Please find below comments from Private Sector Housing:

APPLICATION NO: BR/315/19/PL

Site Address: 98-100 Chichester Road Bognor Regis PO21 5AA

Description of Works: Conversion of the existing first floor office space (B1 Business) into 1 No. two bedroom flat (C3 Dwelling house) including rear access, amenity space & general storage facilities.

FIRST FLOOR PLAN

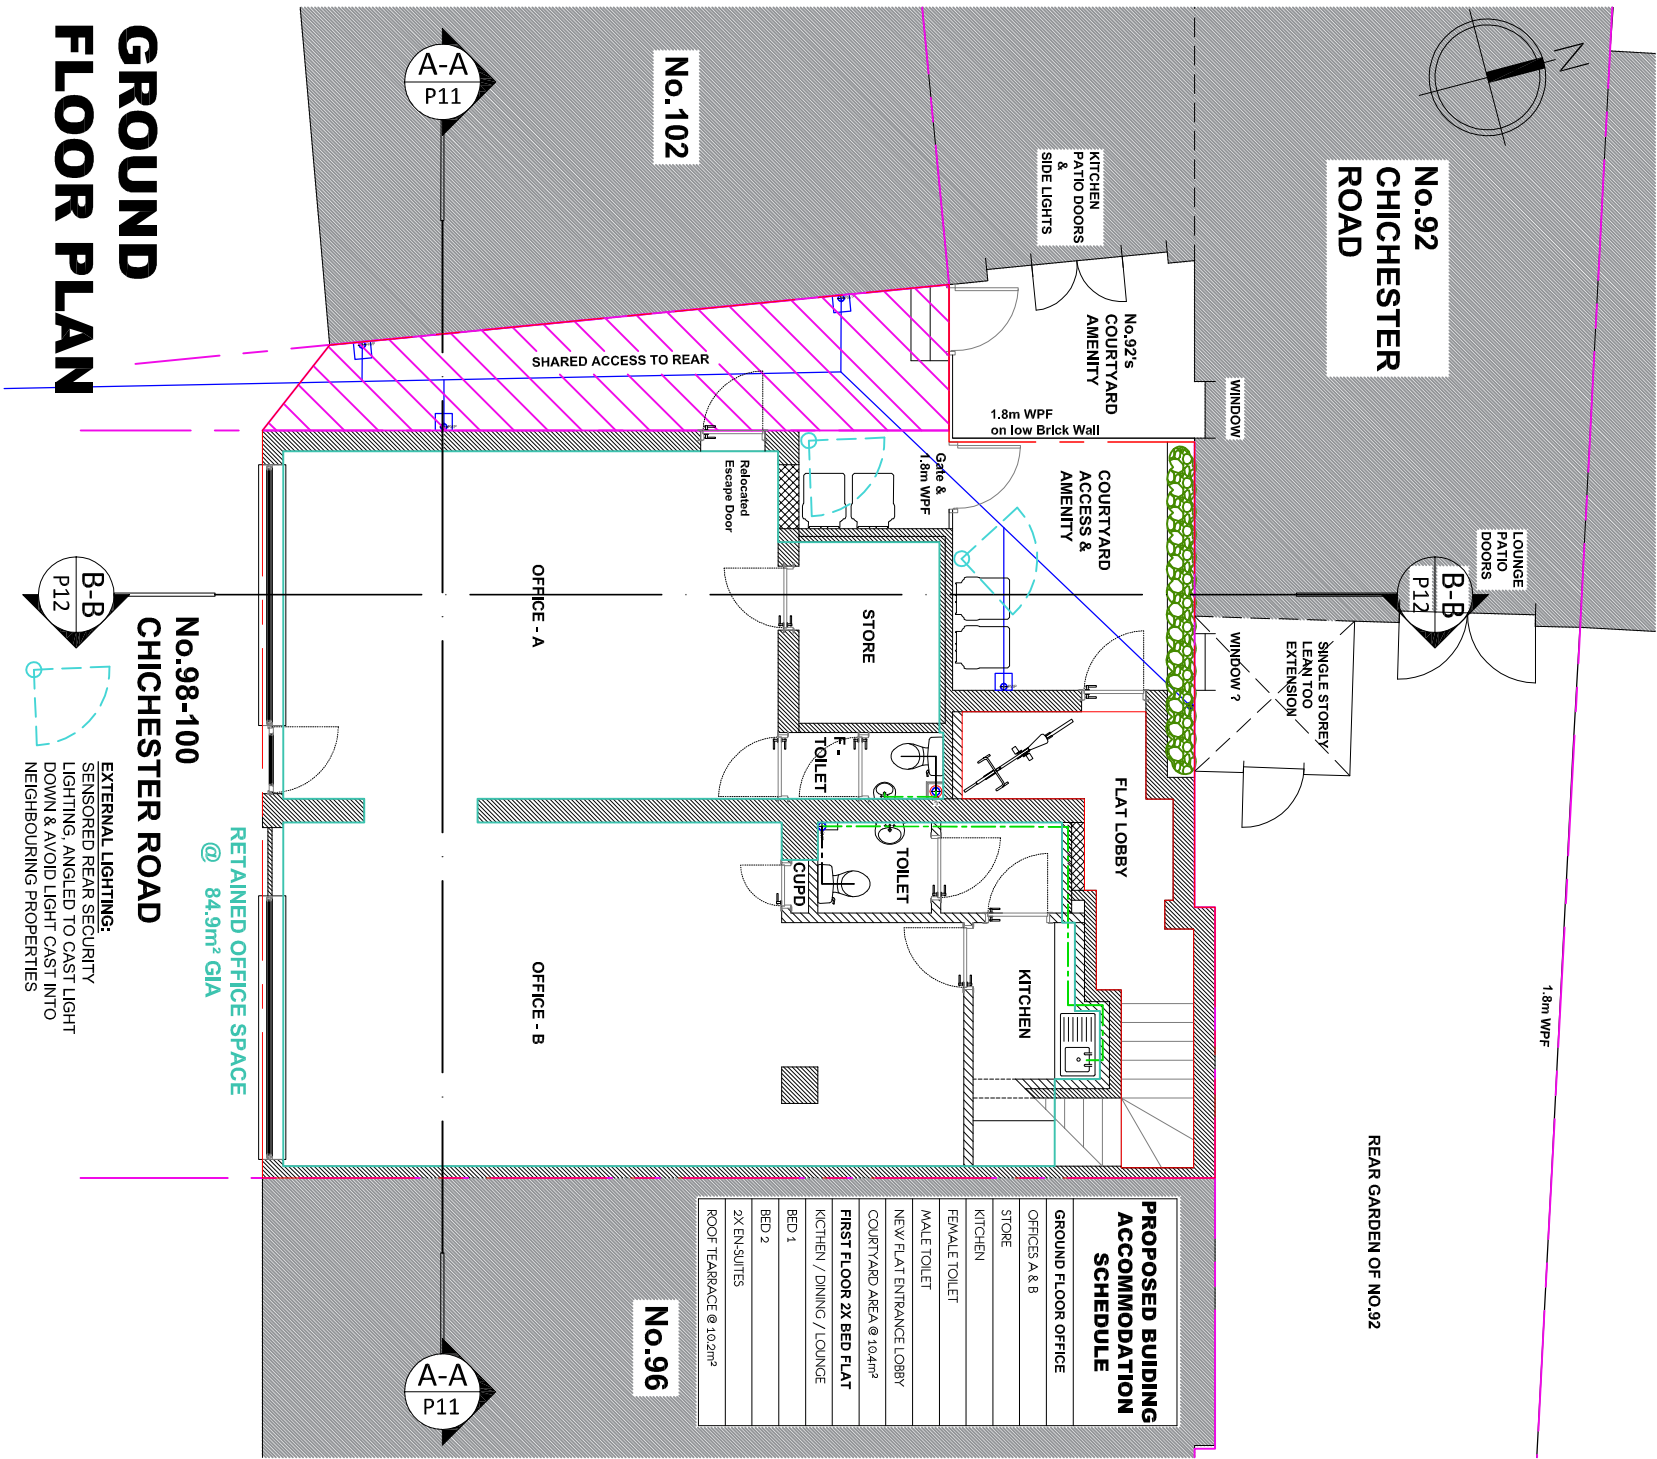
- The escape route from Bedroom 1 is via a high risk area, containing the kitchen and lounge. There are doors from Bedrooms 1 and 2 opening onto the decked roof terrace and each of these doors should be fitted with thumb-turn style emergency escape mechanisms. It is assumed that a section of the galvanised and glazed barrier being reduced from 1800mm to 1100mm has been done so in order to provide an alternative means of escape. If this is correct, the barrier must also be rated to an adequate load bearing capacity to be used as a means of escape and the requirements of a suitable escape window must be met for this to be acceptable. This includes the height of the barrier, the suitability of the surface beneath the escape level and the occupiers expected to use this means of escape. Suitable artificial escape lighting should also be provided to illuminate the external escape route.

Bedroom 1 must also be fitted with a suitable fire door, as determined by a risk assessment, but must be a minimum of FD30S standard. The wall separating the kitchen/lounge area and Bedroom 1 must also afford a minimum of 30 minutes fire resistance.

- Bedroom 1 is an inner room. An alternative to the second comments above could be to enclose the kitchen and lounge areas and for these to be fitted with a minimum of a conventional close-fitting door, thereby overcoming the inner room scenario (single household). If the property is to be occupied as a Flat in Multiple Occupation, these areas may need to be fitted with FD30S fire doors and consultation with LACoRS must be made to ensure the right level of fire safety measures are implemented in relation to the intended mode of occupation.

- There should be adequate fire separation between the commercial unit on the ground floor and the residential flats above.
- Grade D, LD2 fire detection and alarm system, comprising (in accordance with the submitted floor plans):
 - Interlinked mains wired smoke detection and alarms with integral battery back-up located throughout the escape hall and stairs serving Bedroom 2, in the Lounge area and in Bedroom 1. Please note that if there are lintels measuring more than 300mm deep, a smoke detector must be sited either side of the lintel.
 - If the property is to be rented out to more than a single household, an interlinked heat alarm with integral battery back-up facility must be located in the kitchen and a Fire blanket also to be provided in the kitchen.
